Rezoning Transportation Analysis
Petition Number: Insert Zoning Petition #2021-219
General Location Identifier: 12521103

From: Brandon Brezeale, PE
Brandon.Brezeale@charlottenc.gov
704-432-5561

Date	Description
01/21/2022	First Review (WB)

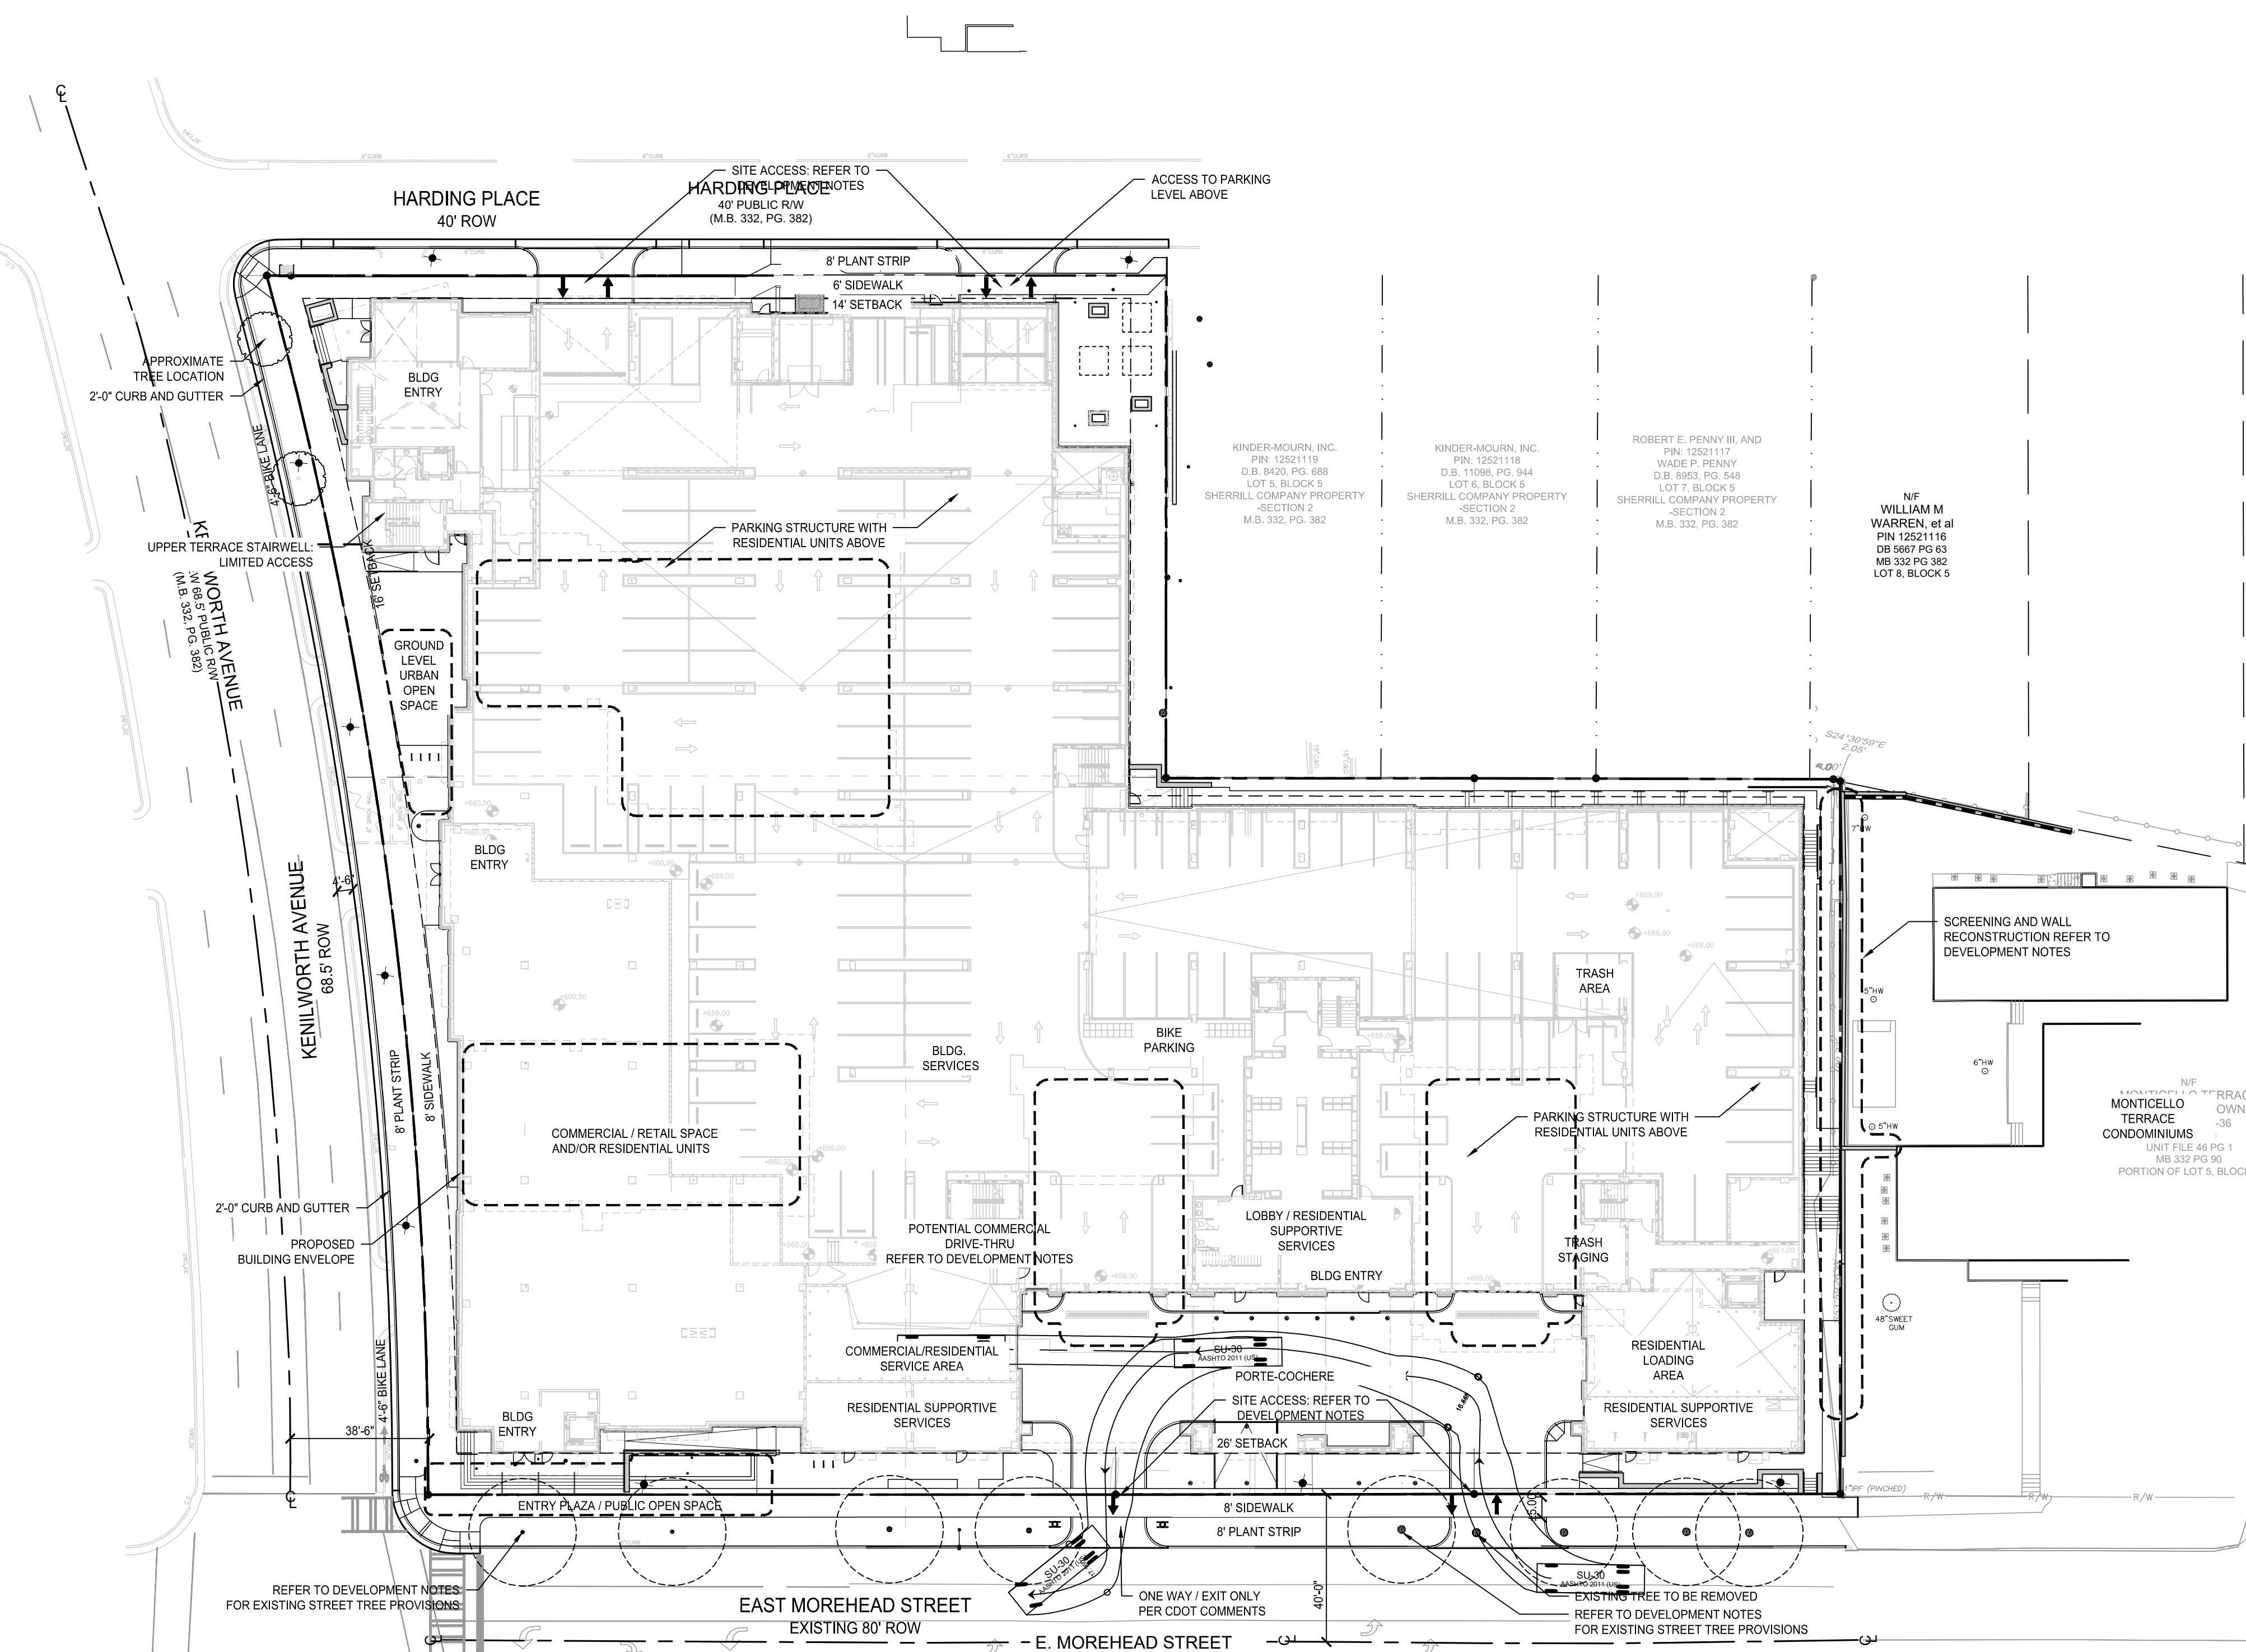
1. **Curbline:** The proposed zoning district has a setback measured from back of the existing or proposed future curbline.
 - a. **Morehead Street:** The future location of curb and gutter measures at 36-feet from the centerline to the back of curb to accommodate buffered bike lanes; however, no curb relocation is being required with this petition and the existing curb and gutter may remain at its current location.
 - b. **Kenilworth Avenue:** The existing curb and gutter is in its future location.
 - c. **Harding Place:** The existing curb and gutter is in its future location.

Label and dimension the curb and gutter from the centerline for each road on the site plan.
